Lead Local Flood Authority

Date 20 August 2026

RE: WA/61/26/PL - Riverwood Centre, Yapton Lane, Walberton, BN18 0AS.

We **object** to this planning application in the absence of an acceptable Flood Risk Assessment (FRA) and Drainage Strategy relating to:

TITLE:
Post-Development Impermeable Areas.

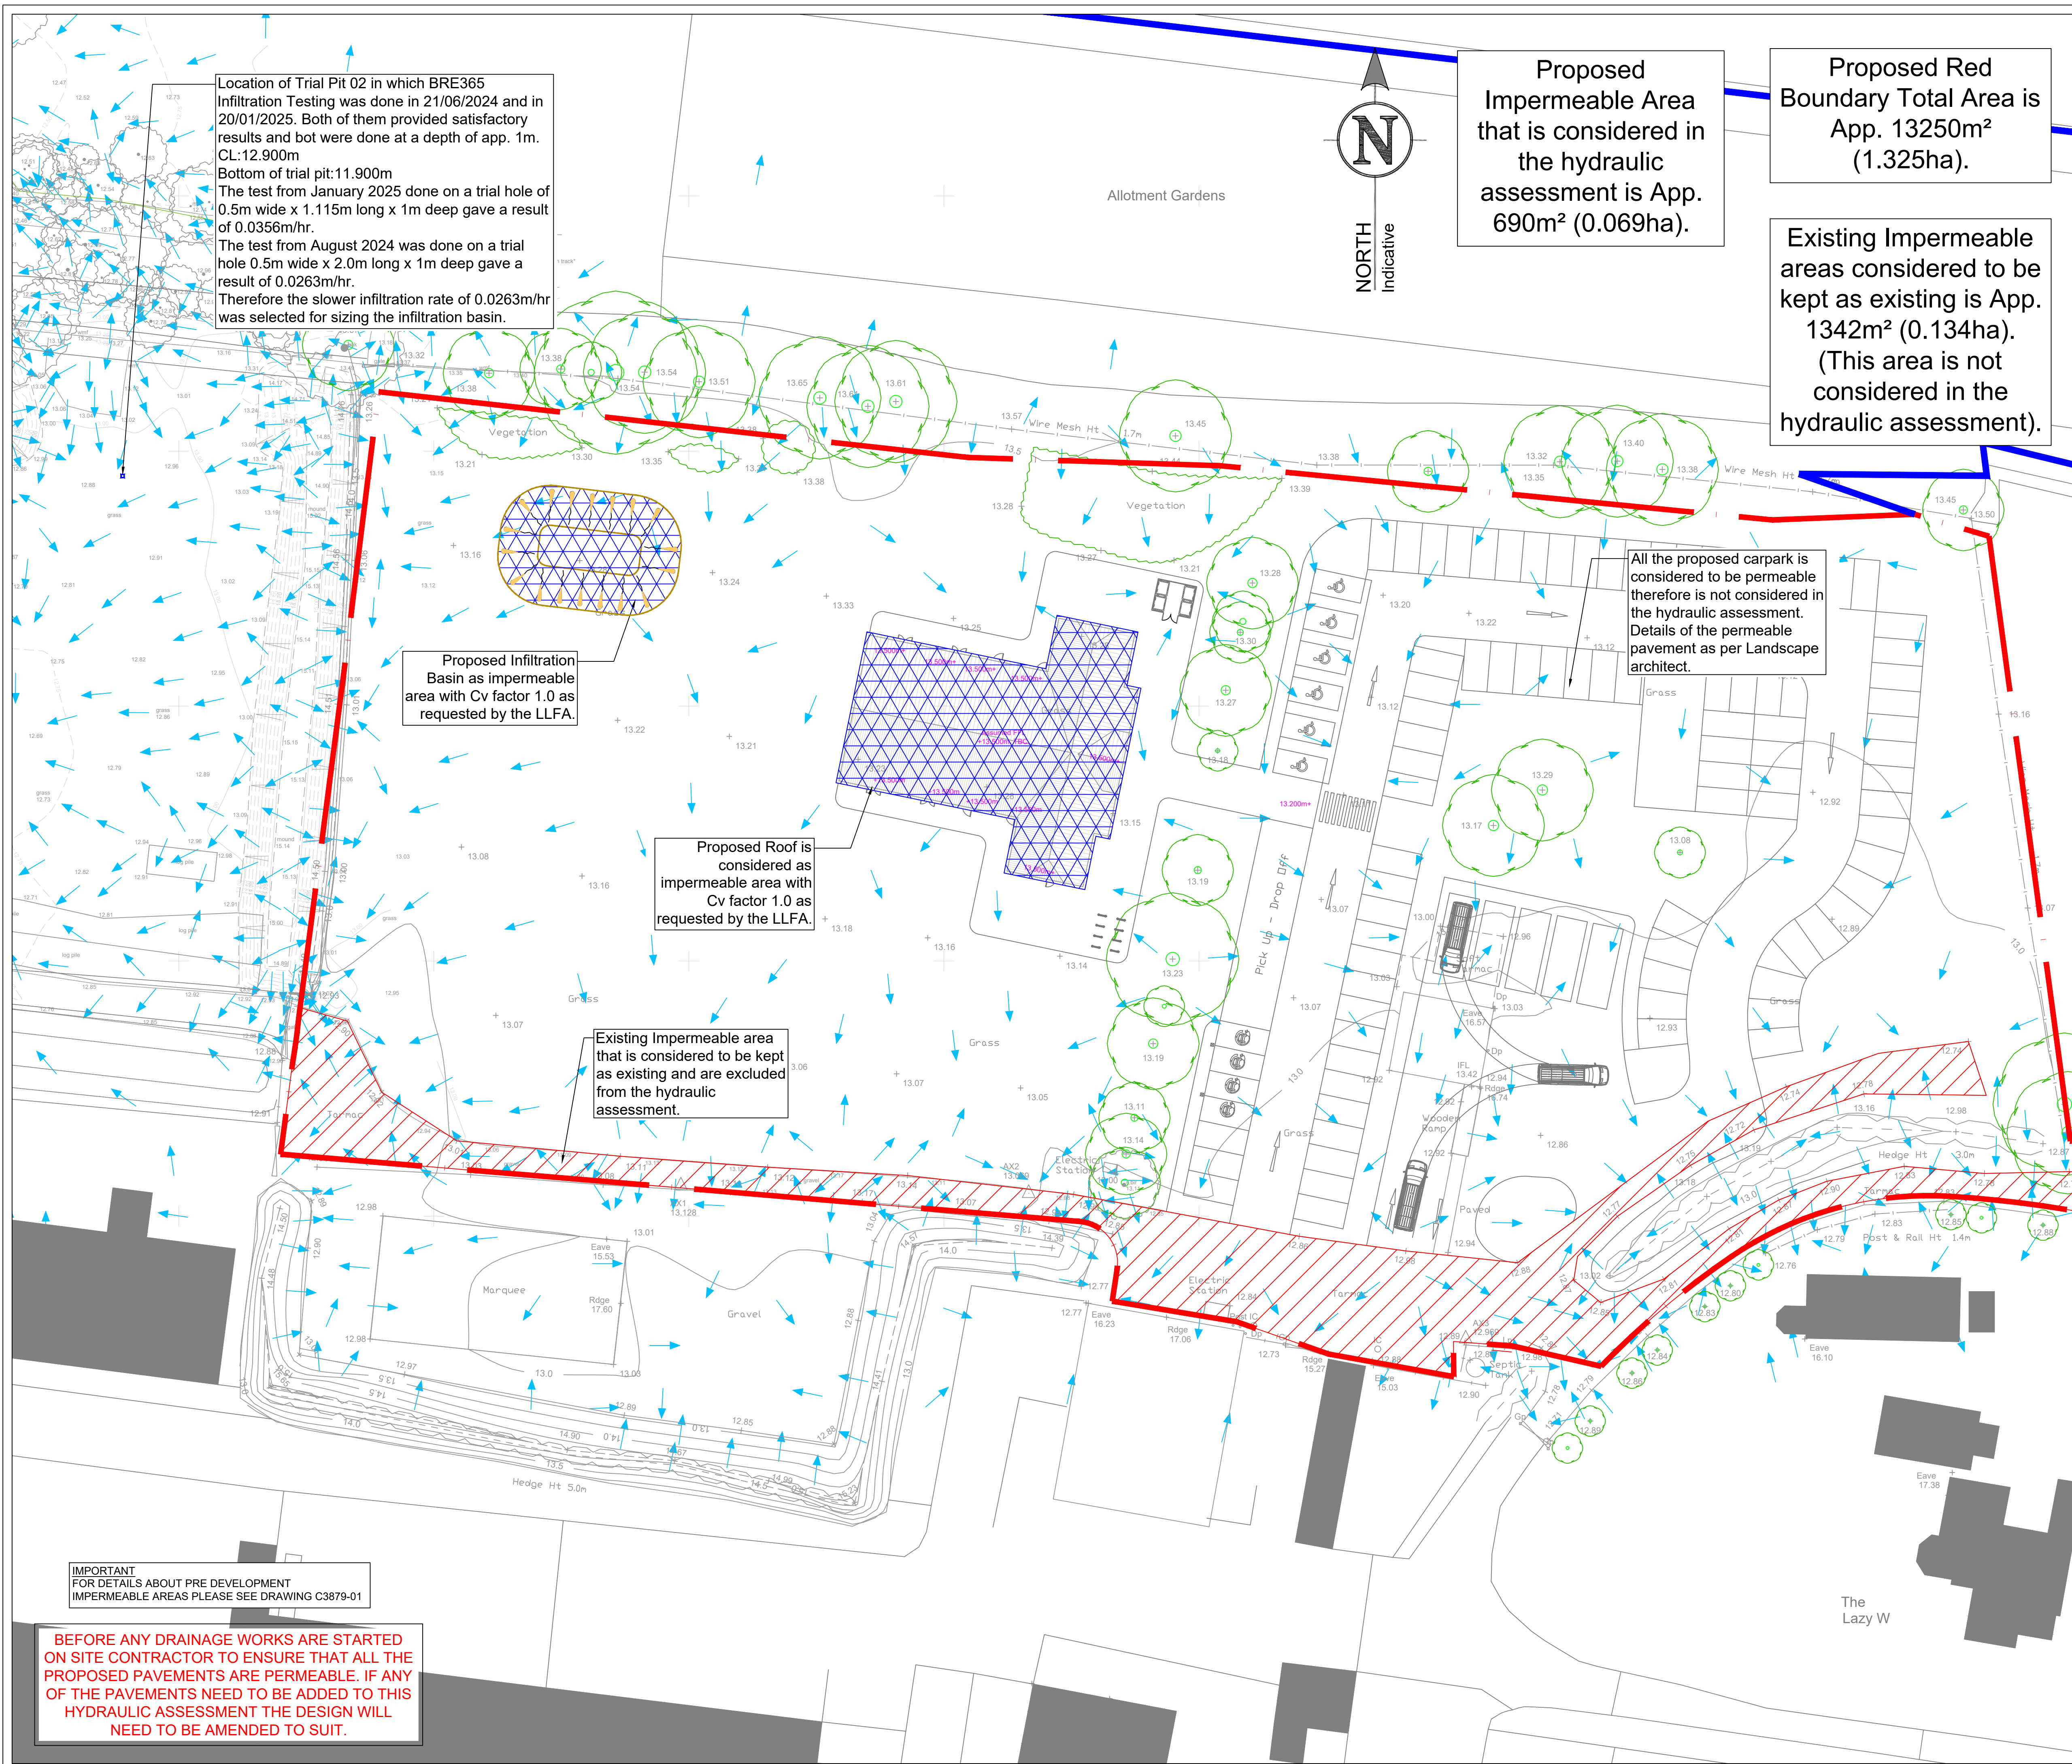
2. A complete set of hydraulic calculations for the entire site are required to ensure the proposed surface water drainage network can appropriately drain the development to current standards (eg FEH2022, CV=1 both Summer and Winter, Climate Change 45%), ensure storage quoted can be achieved at a range of rainfall event scenarios.

8. Further clarification with respect to exceedance. Many references to "follow the site's natural topography" however updated plans/further evidence in form of exceedance drawings, depths, pathways to demonstrate that any property remains dry remain dry.

9. A short briefing note with appropriate signposting to How the development incorporates the National Standards for SuDs. (June 2025)
10. Clarification of the land ownership and site red line boundaries. Plans within FRA show connecting features to ordinary watercourses 'off site'

TITLE:
Proposed Surface Water Maintenance and Management Plan.

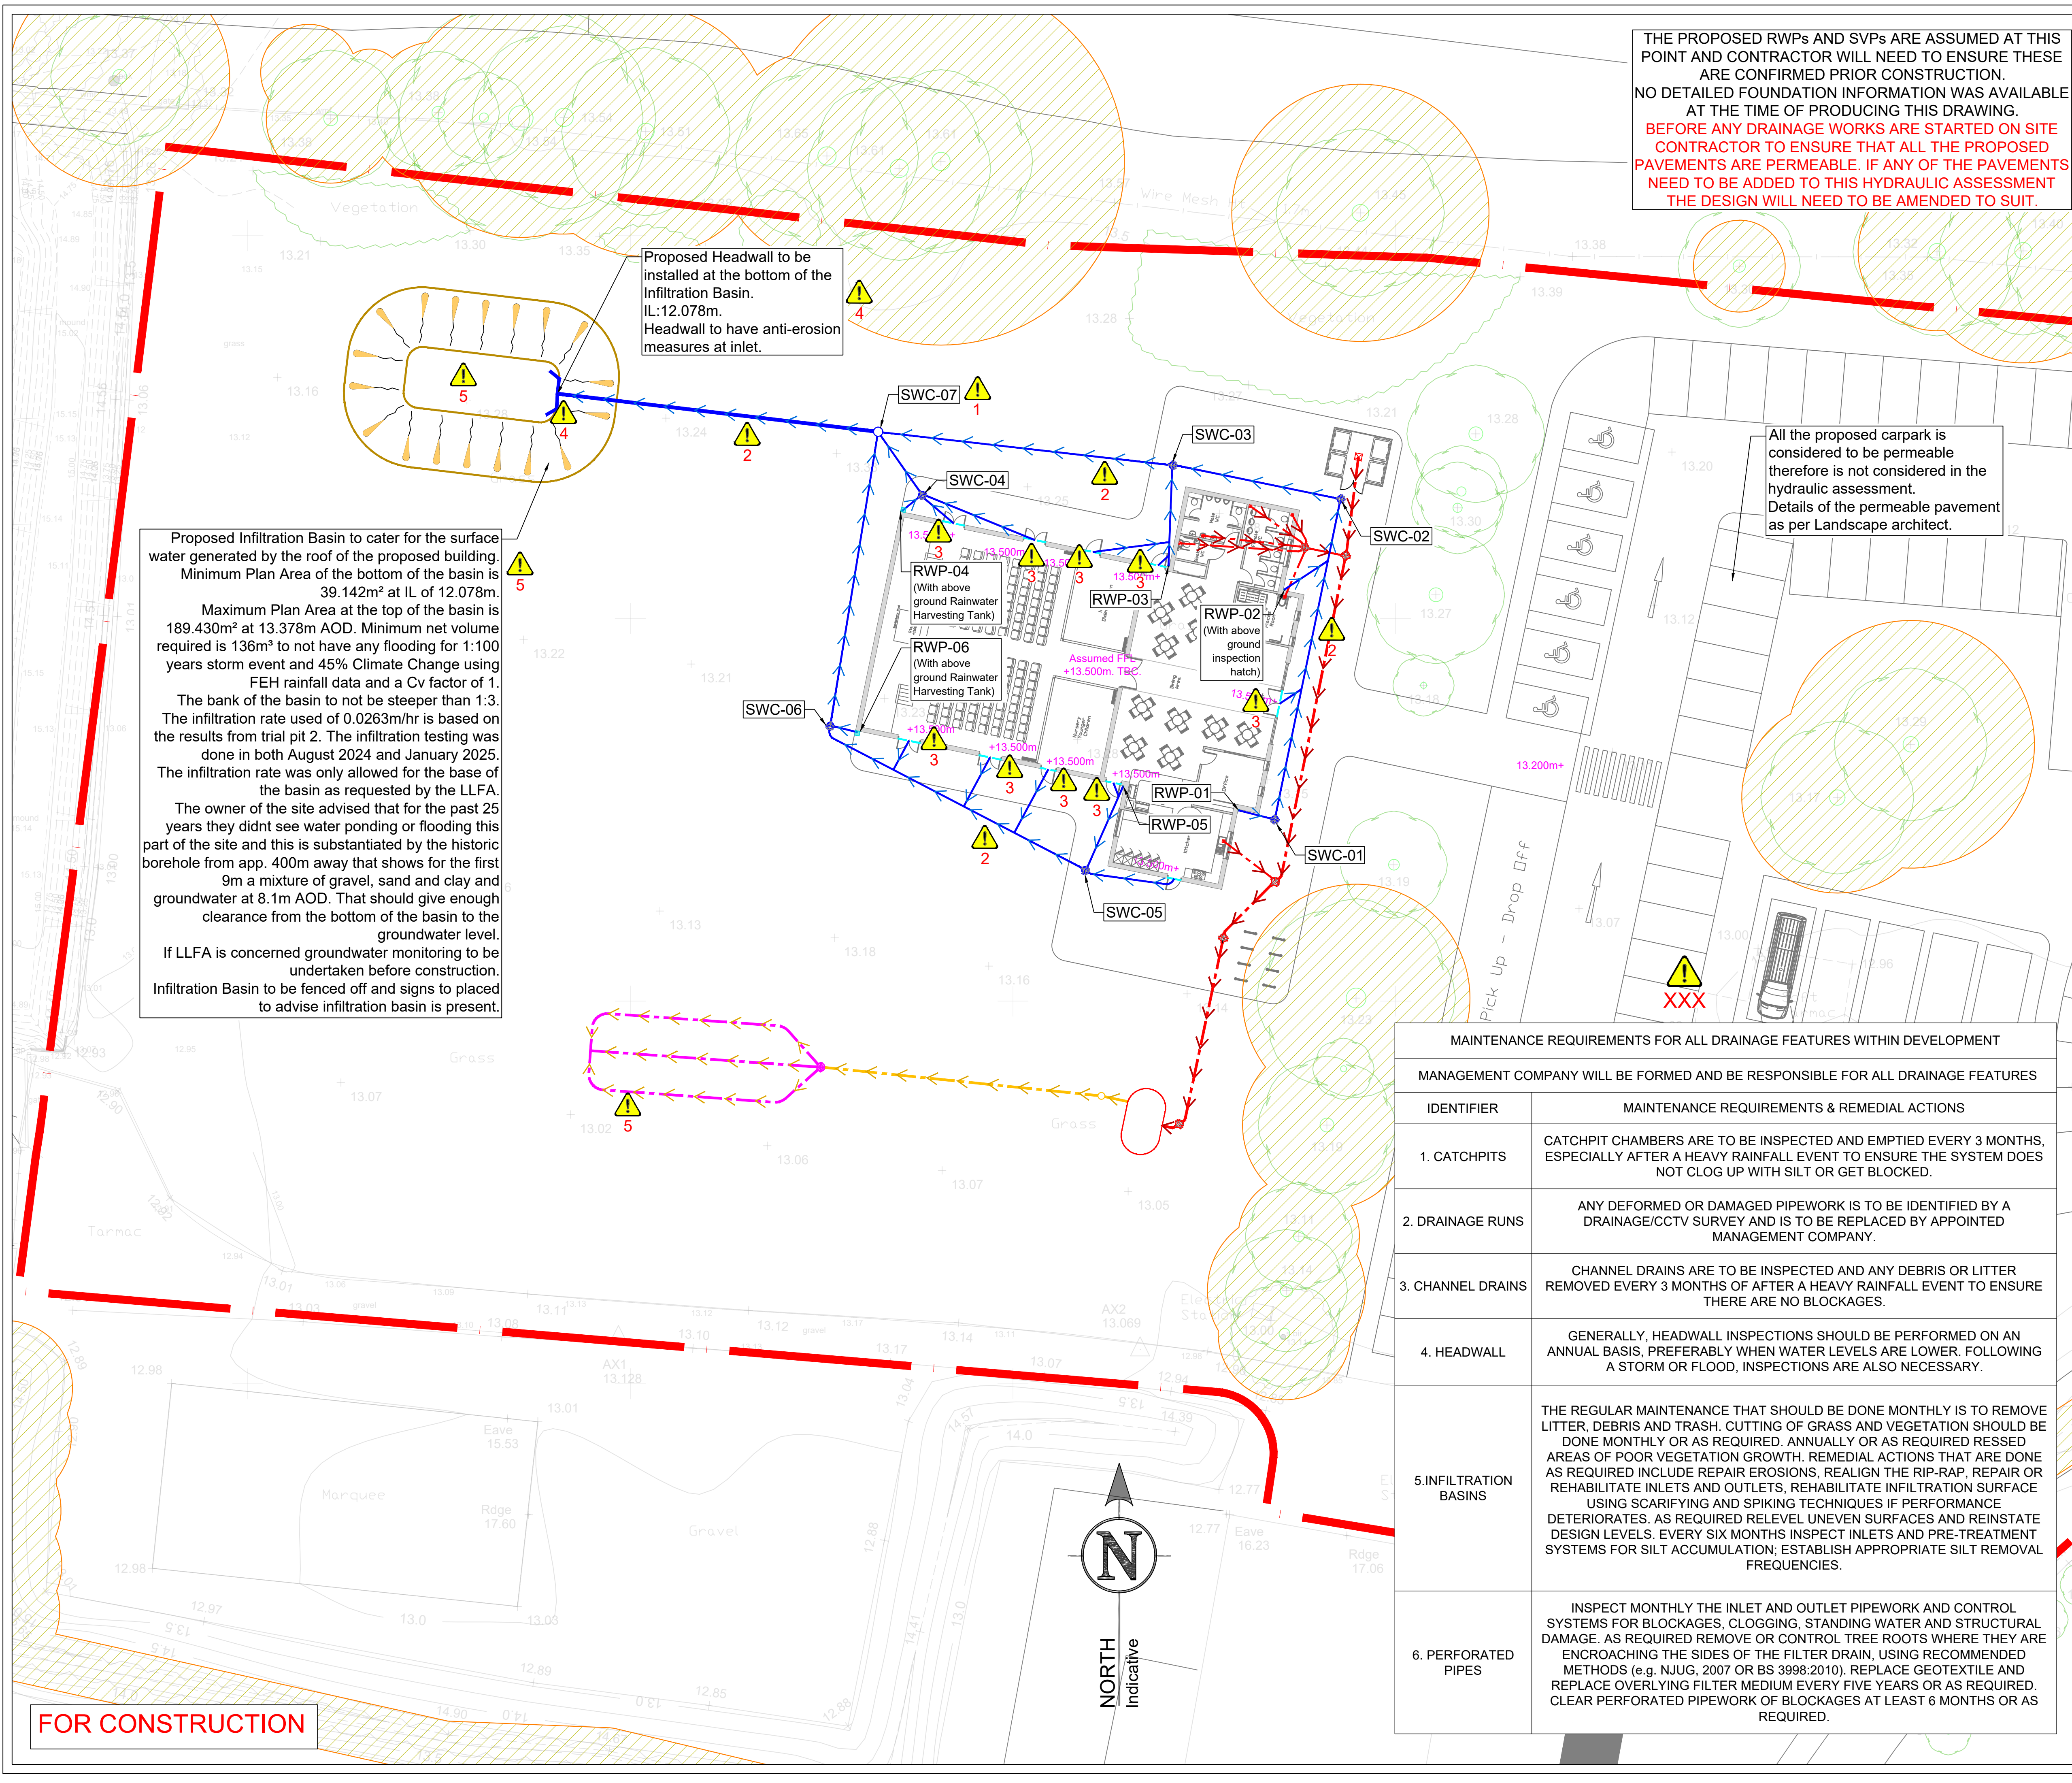
3. Further site specific details of the maintenance and management of SuDS features is required due to the design refresh. **This can be conditioned, although we recommend early consideration of management and maintenance.**
